Planning Application 3/2022/0990

name
proposed plans and elevations

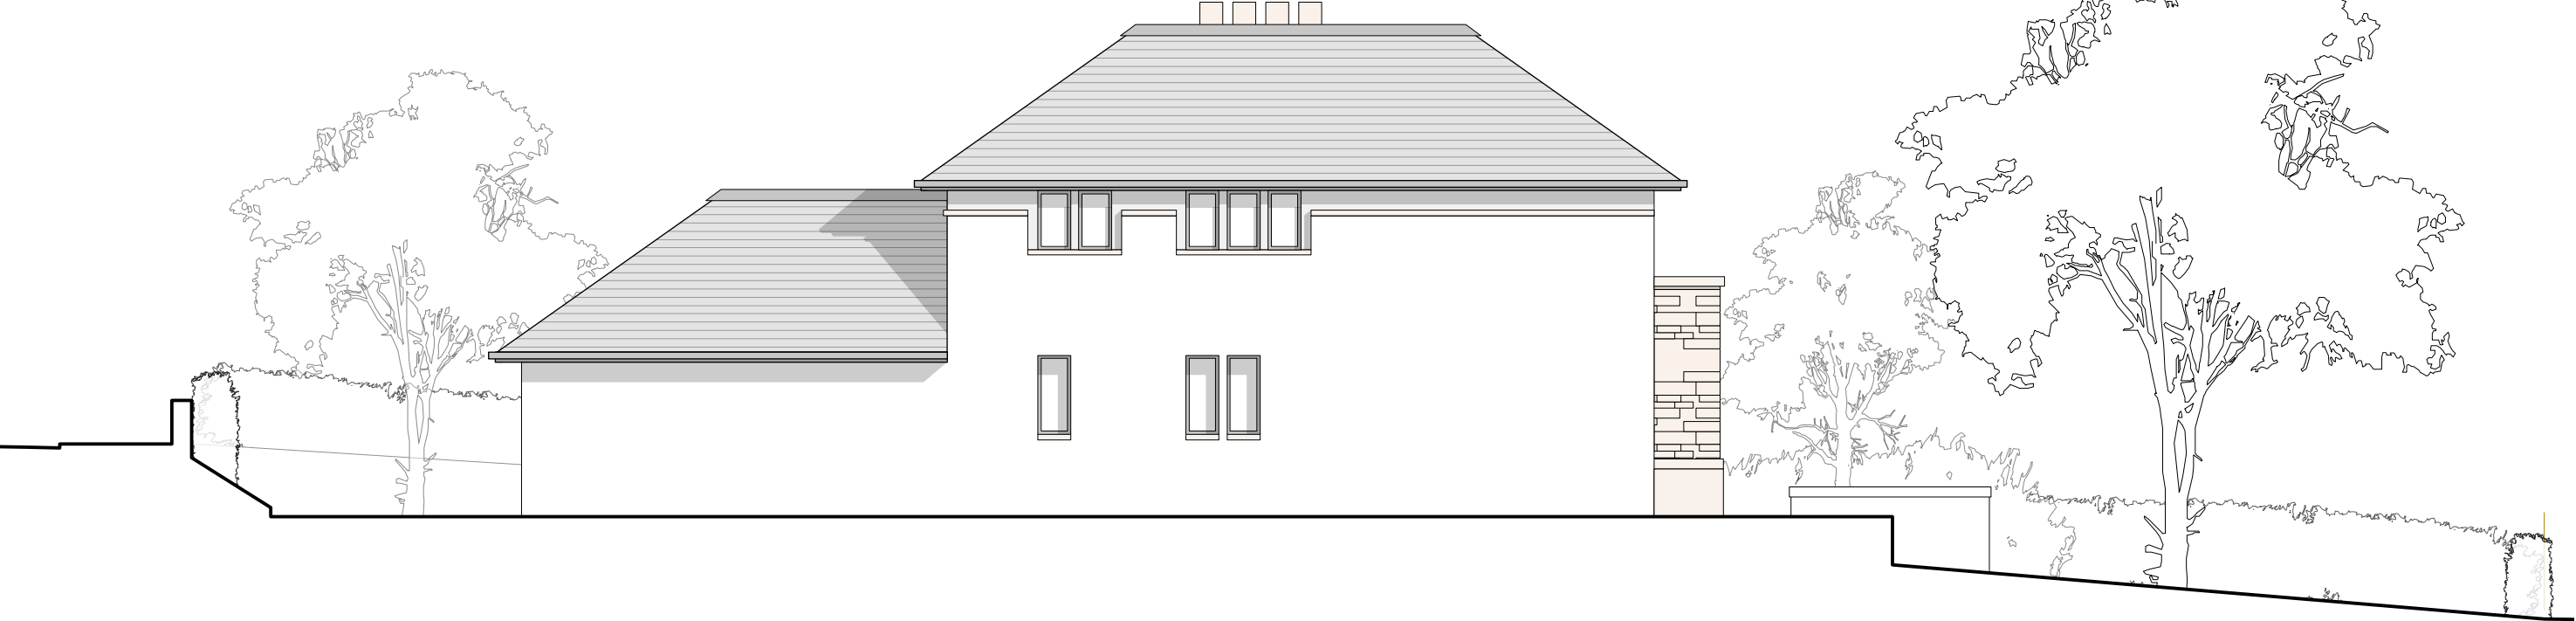
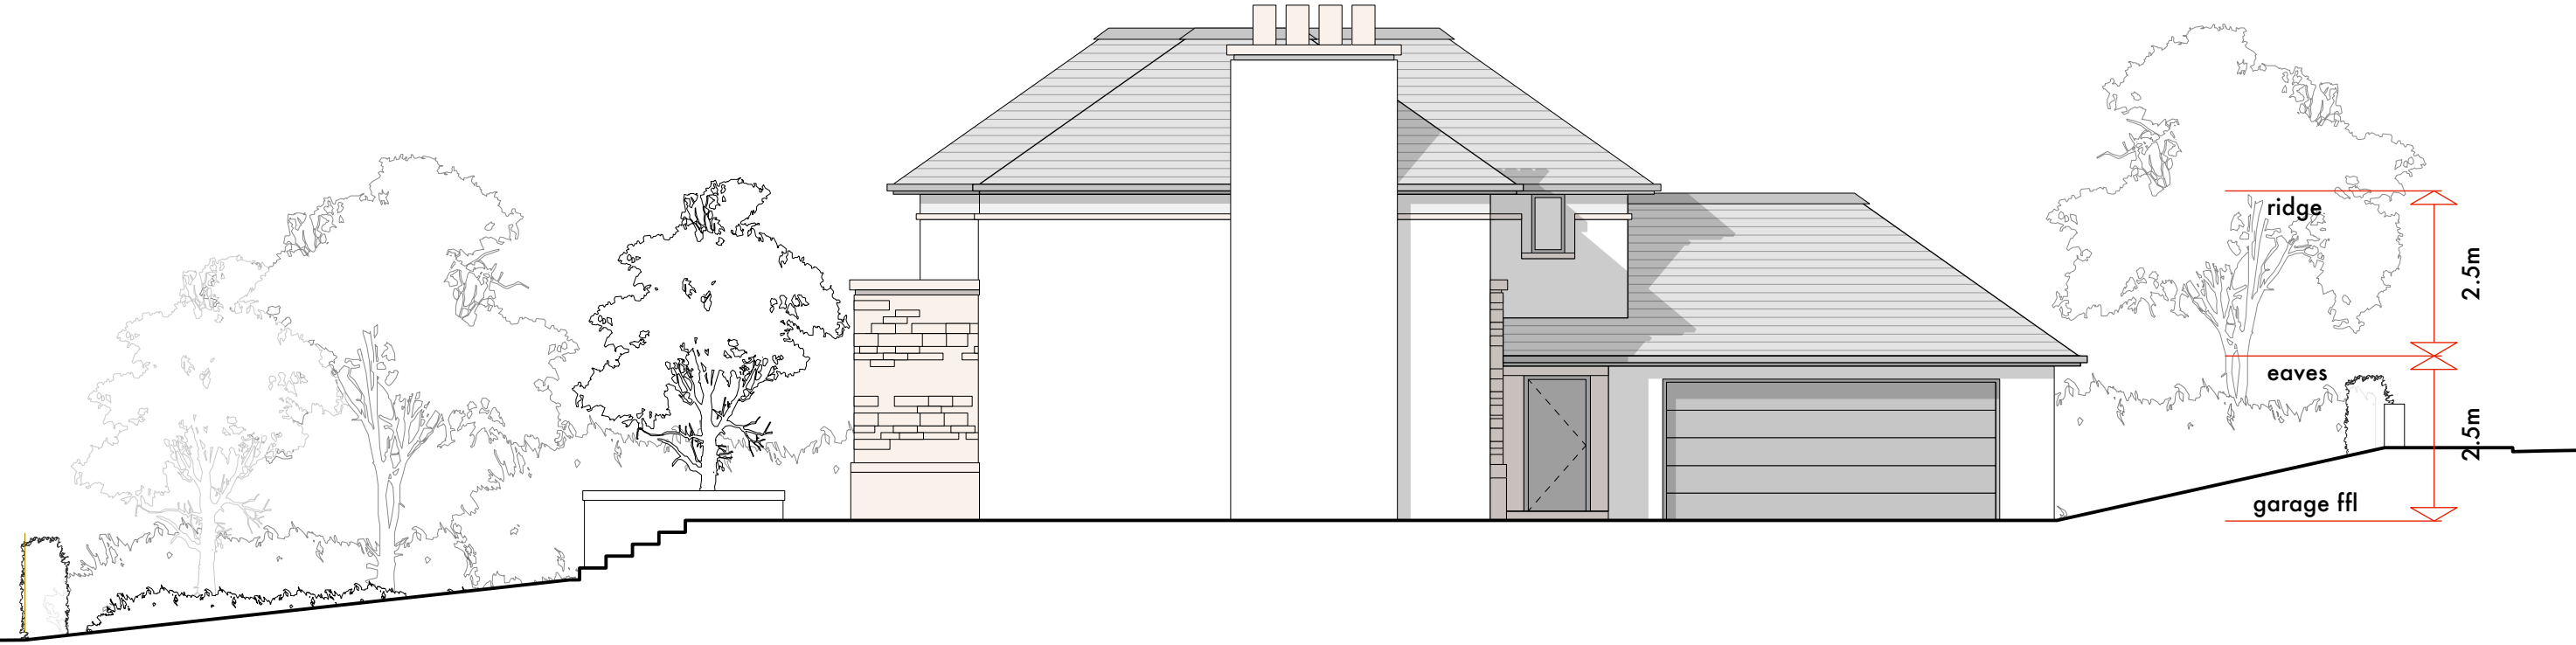
2 The all rendered, stonework and aluminium frames are too modern a finish for this unique area. [REDACTED] was required to be built of brick with some rendering to blend in with Ribblesdale ave and the Knuck Knowles estate. This new property is all render and some stonework. There are no completely rendered properties along Ribblesdale avenue proper. The stonework is completely out of character and makes [REDACTED] The last property to be built on Ribblesdale ave is completely brick. Also the property to be built [REDACTED] is completely brick. Therefore the property in question is completely out of style with the rest of Ribblesdale ave. properties

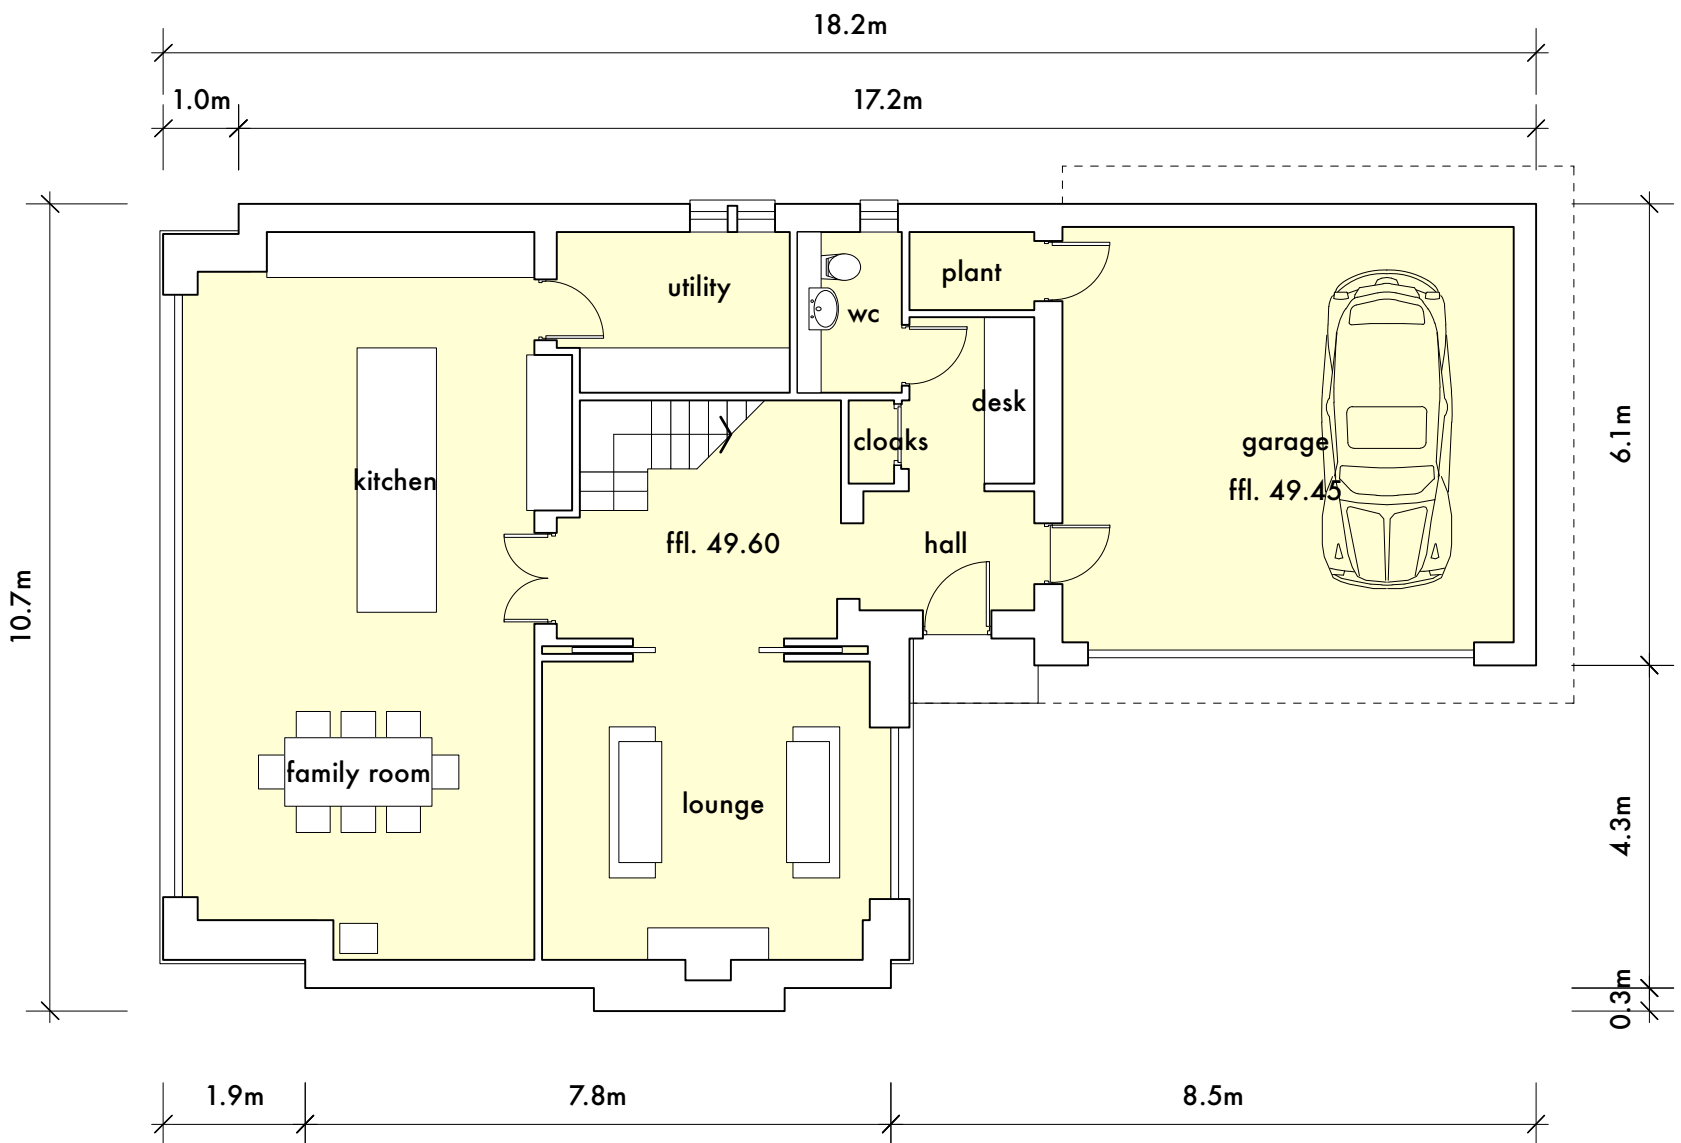
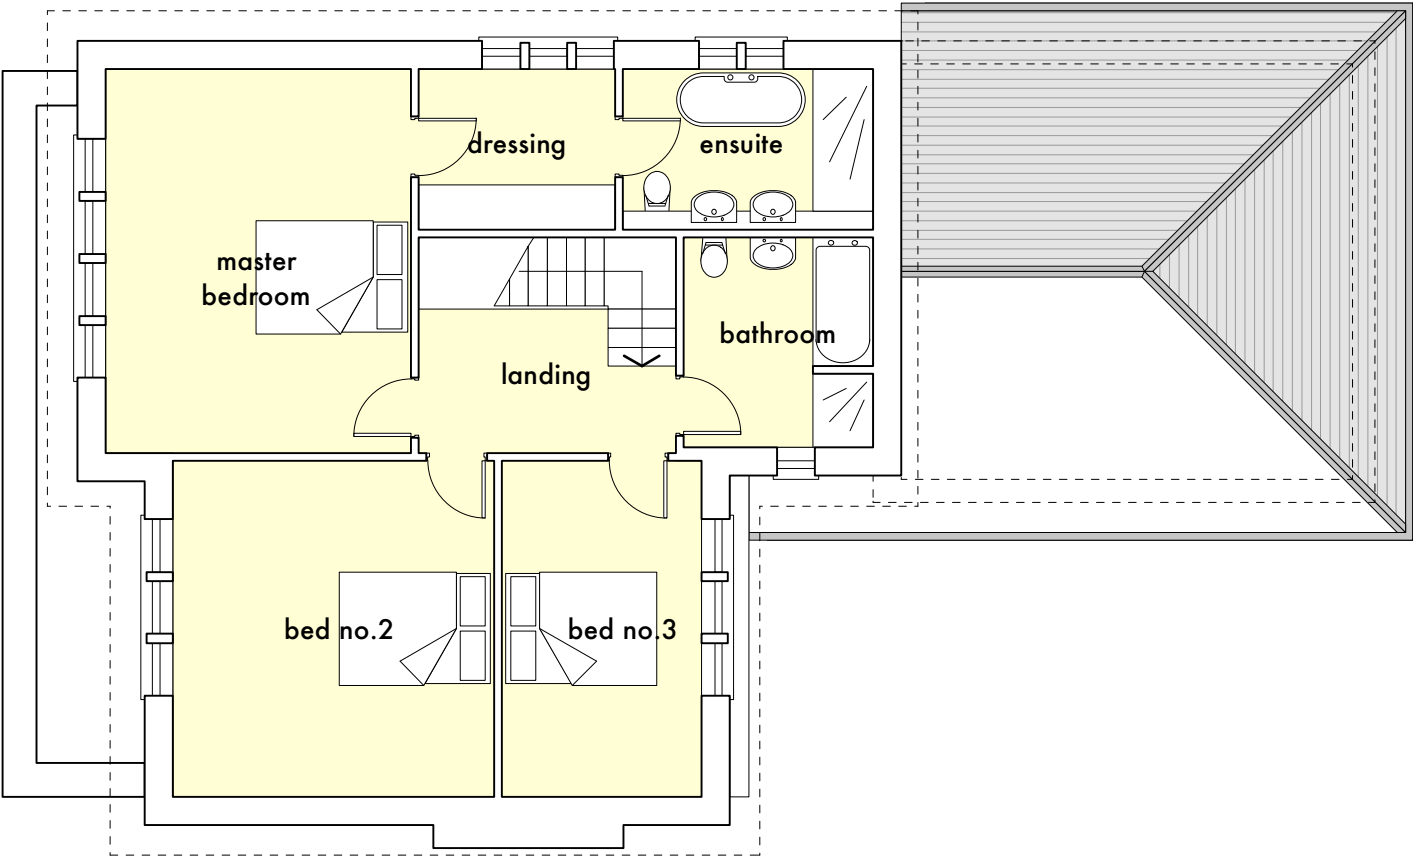
3 I do not understand why there is a chimney breast.
If it is for a log or coal burning stove, I believe
we are being encouraged by the Government to stop
burning logs/coal. Surely R.V. P.C. are aware of
this fact and must encourage us to be more
environmentally friendly.
